Consultation Response from KC Conservation and Design		
2019/91194 Thorpe House, 22, Finthorpe Lane, Almondbury, Huddersfield, HD5 8TU		
Listed Building Consent for demolition of existing outbuildings and erection of two dwellings and erection of extension to existing dwelling		
Date Responded: 05/06/19	Responding Officer: Craig McHugh	Responding Ref: HUD 40/514
Summary Thorpe House dates from the mid-19th century or earlier and has an attractive and extensive landscape setting. The principle of the proposed development is acceptable on heritage grounds although consideration should be given to revising the layout, form and detailing of the proposed semi-detached dwellings. Their scale should be reduced or further justification be provided to support the existing scale. The development would cause less than substantial harm and that harm will need to be balanced with the public benefits of sustaining the present use of Thorpe House and the provision of additional specialist adult mental health accommodation. Significance of the heritage assets affected Thorpe House dates from the mid-19th century or earlier, throughout the 19th century and early twentieth century the property and t

Plans & Elevations

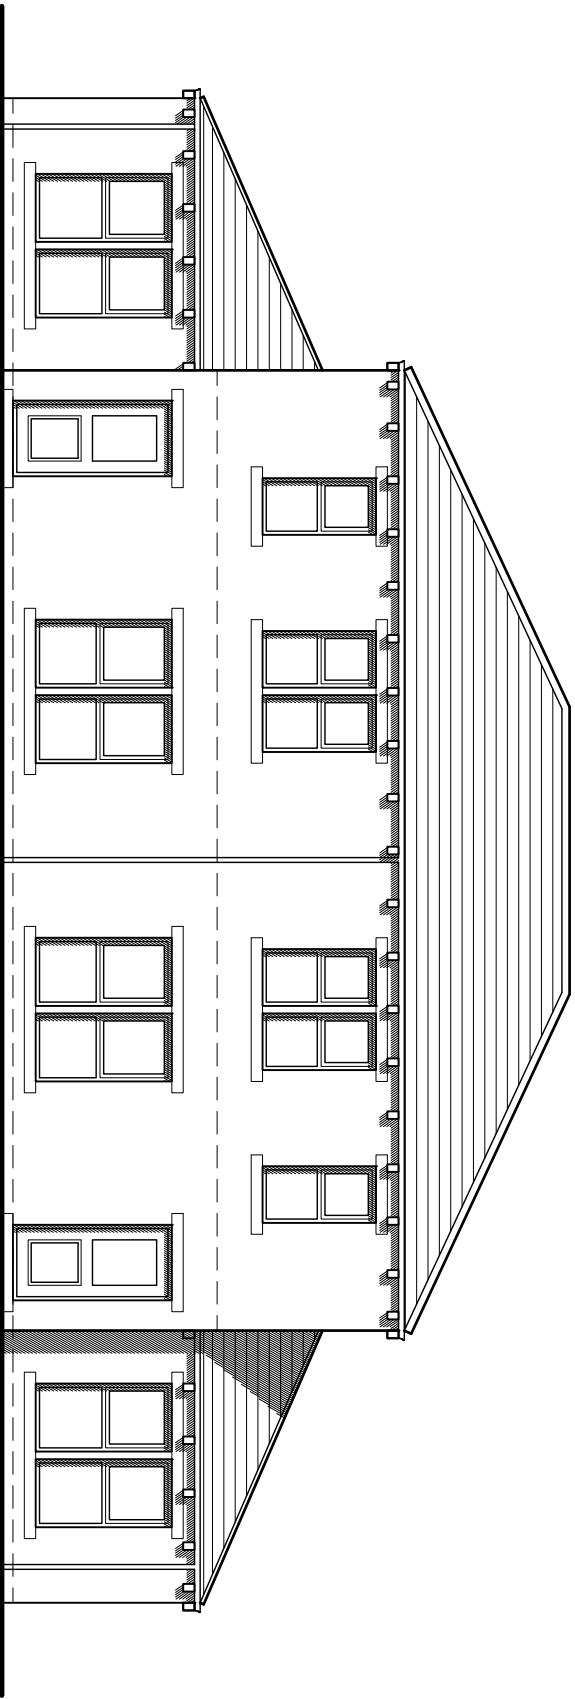
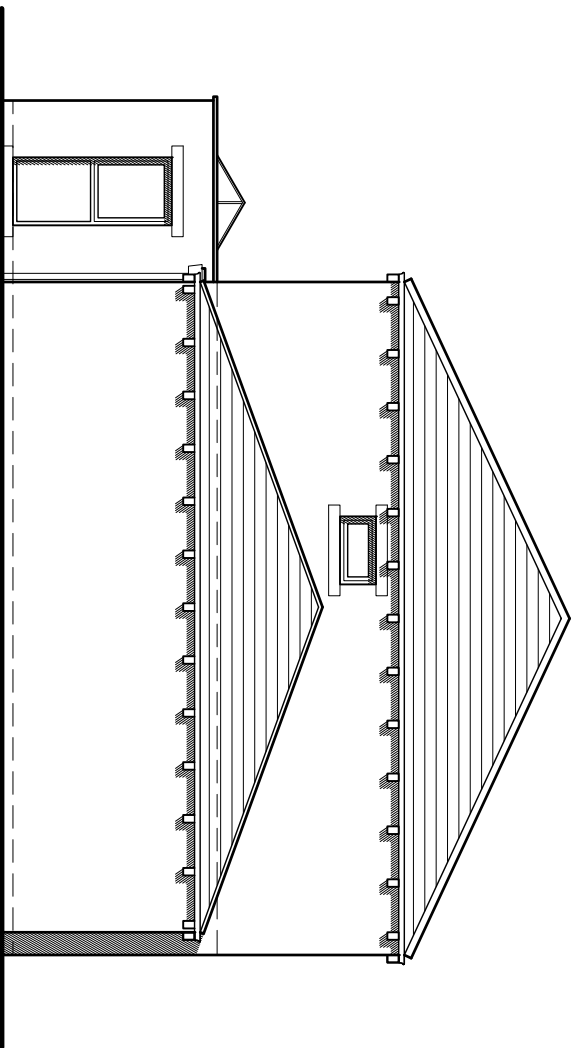
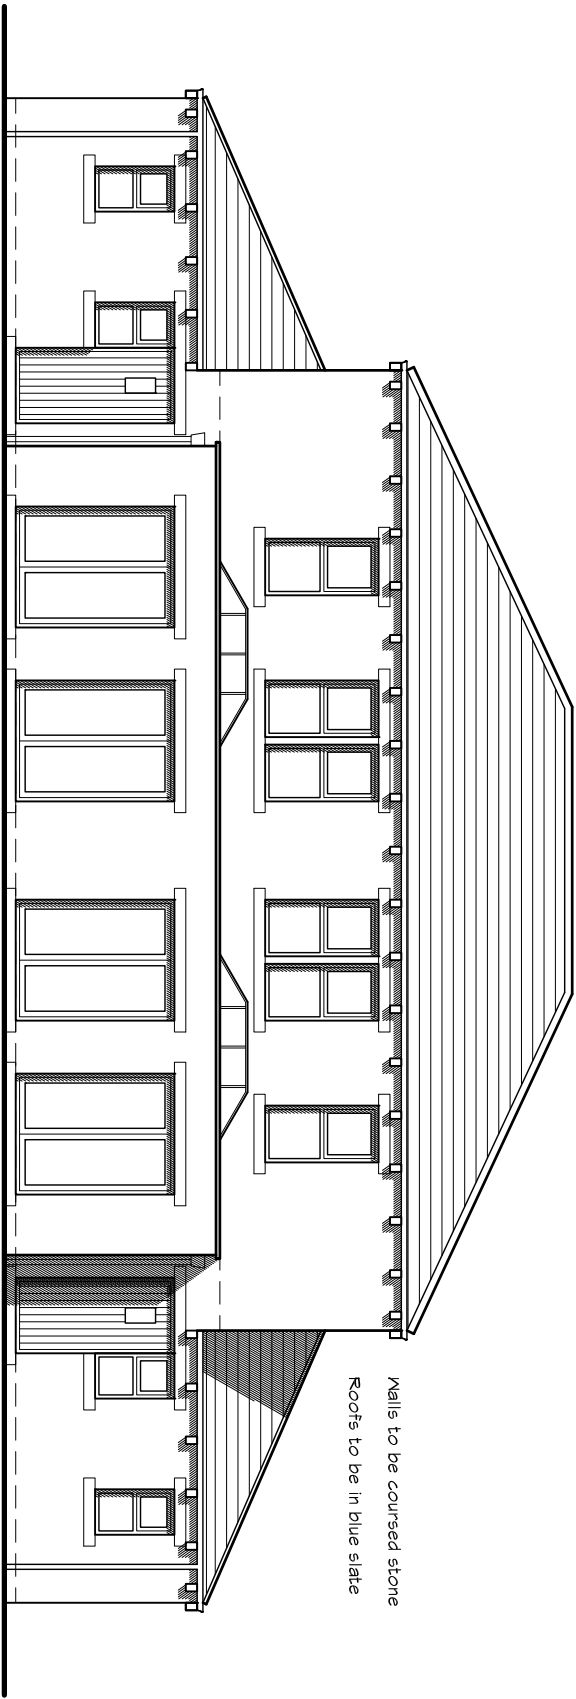
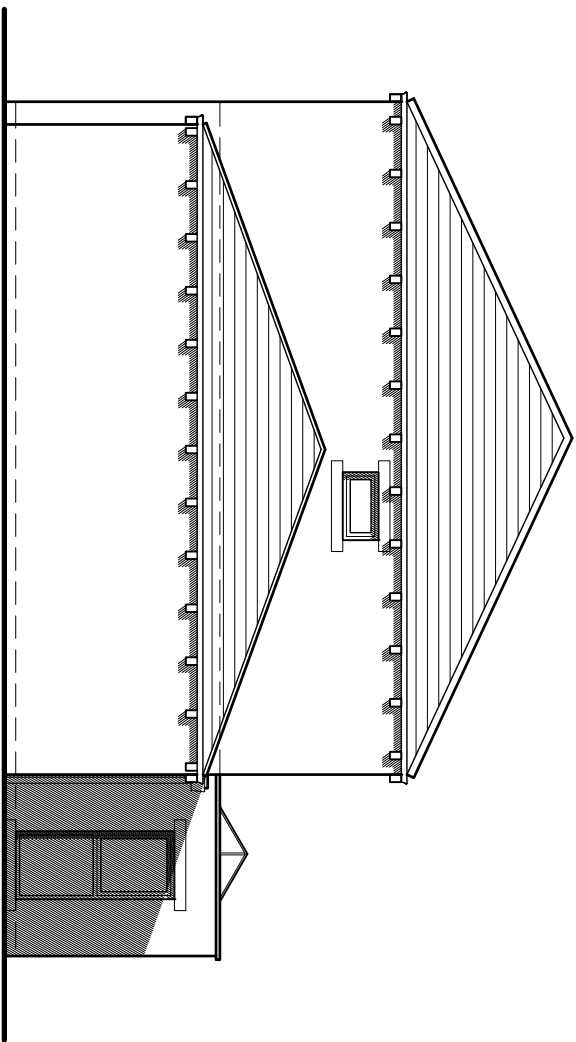
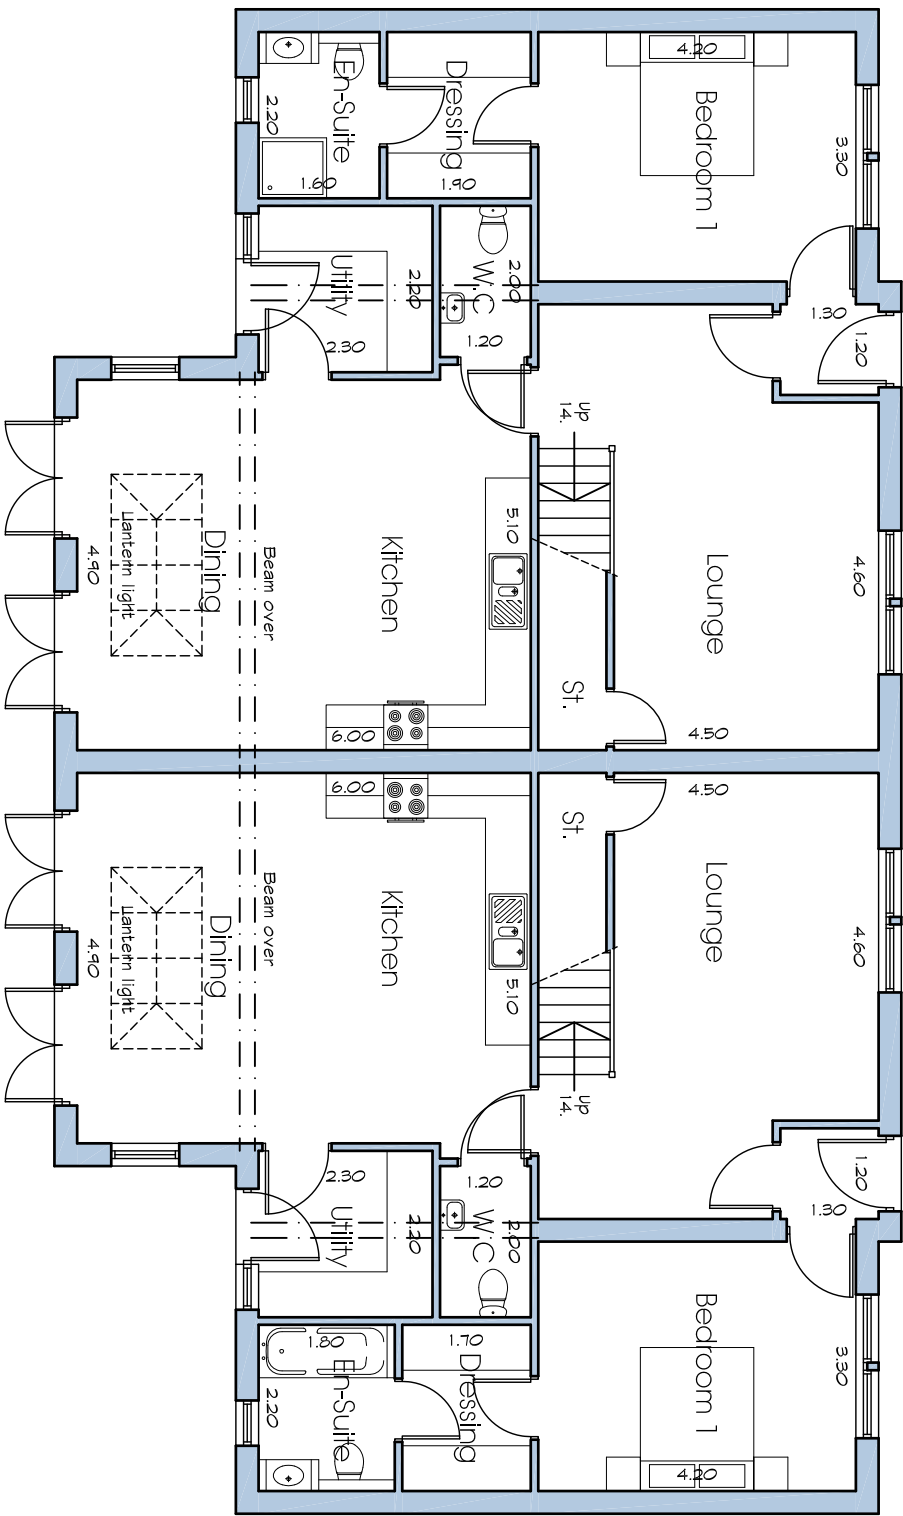
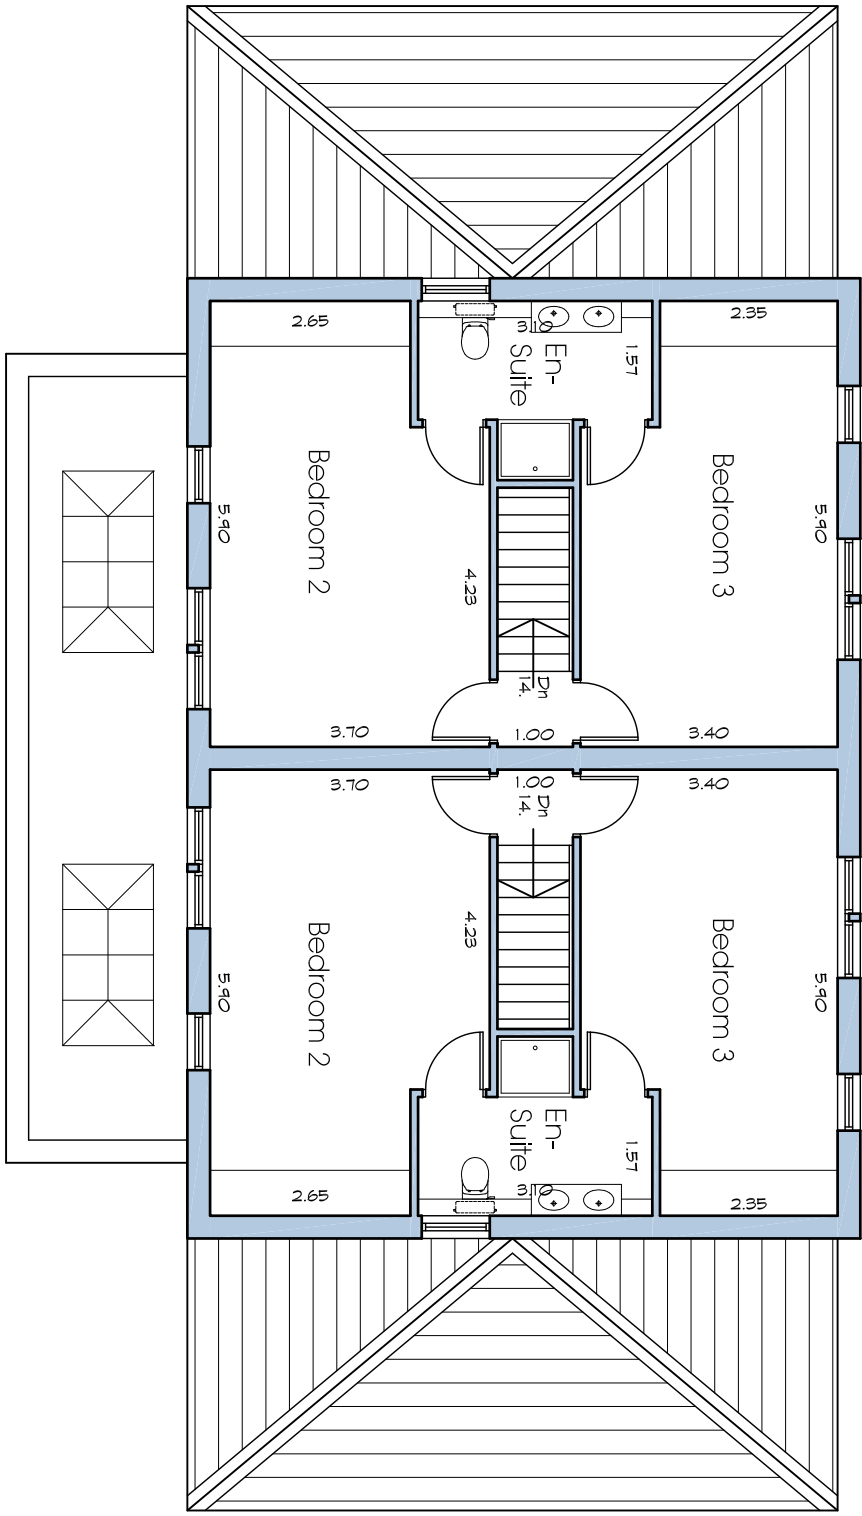
and blue slate roof is welcomed. The layout could be improved with respect to the setting of the listed building by pushing the property further towards the north of the site. The ground floor area of the building is approximately 30% larger than the existing owner's accommodation. We should request further information on the volume of the proposed development relative to the existing buildings including Thorpe House. The concern being that the scale of the proposed houses may challenge Thorpe House, which is the principal building on the site. It is noted that the applicant has specific requirements with regards to supporting the business on site, which requires a ground floor bedroom to each property. However, with regards to the design of the building, this could be improved through a simpler form (i.e. without front and side projections) and the addition of a more apparent front entrance. The proposed development would cause a low level of harm to the setting of Thorpe House, this harm would be less than substantial harm.

Conservation and Design support the proposed development in principal with regards to paragraph 192(a) of the NPPF but have concerns about the designs of the proposed owner's accommodation on design and heritage grounds particularly with regards to Policy LP 24 of the Local Plan and paragraphs 190 and 194 of the Local Plan.

We should seek to reduce the scale of the proposed replacement owner's accommodation or alternatively the applicant's should provide further justification for the increased size.

We should seek to improved designs for the proposed replacement owner's accommodation with regards to their layout, form and detailing.
